Application No: P/73/21/HH  
Site Address: 6 The Green Pagham PO21 4RZ  
Description of works: Loft conversion to form new first floor with front and rear dormer projections (resubmission following P/21/21/HH).

Thank you for your internet representation made on 5th June 2021 which has been recorded as an objection with the comments as follows:

sheet 1 a of 3

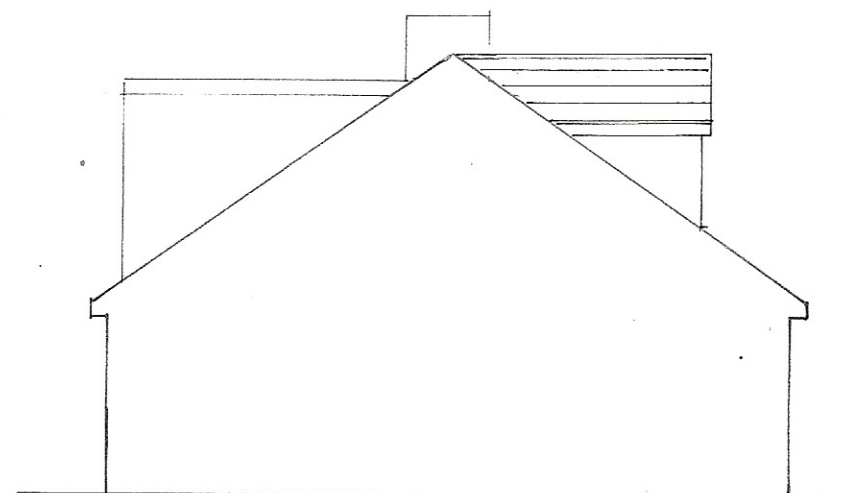
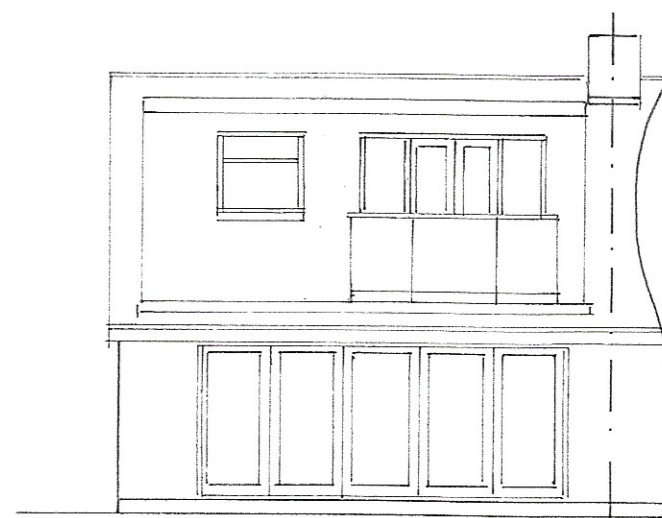
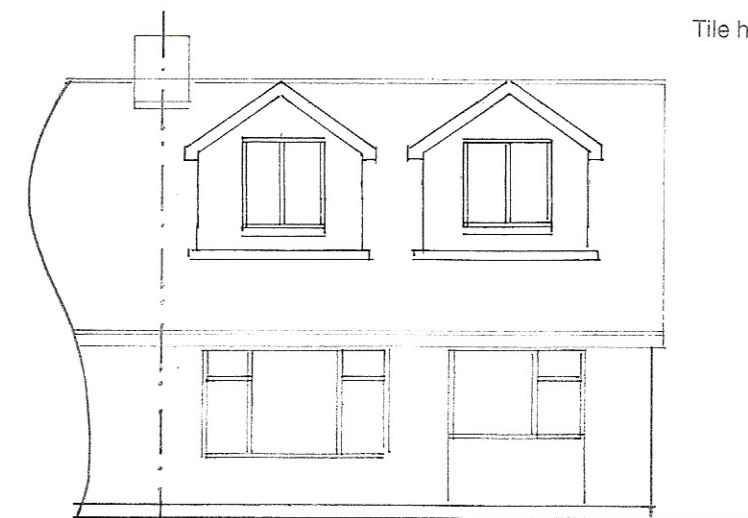
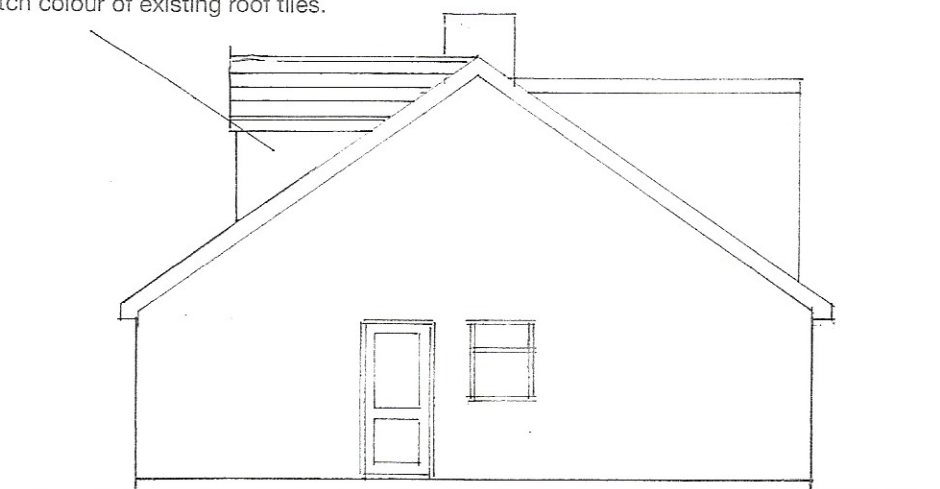
My comments are the same as previous in that I am against development of the front as this is out of line with the other bungalows in the road. In addition how can a two bedroom SEMI DETACHED bungalow be converted to a three bedroom (in effect ) house. I gather the plans include the removal of internal walls which could affect the structure of this AND the attached property
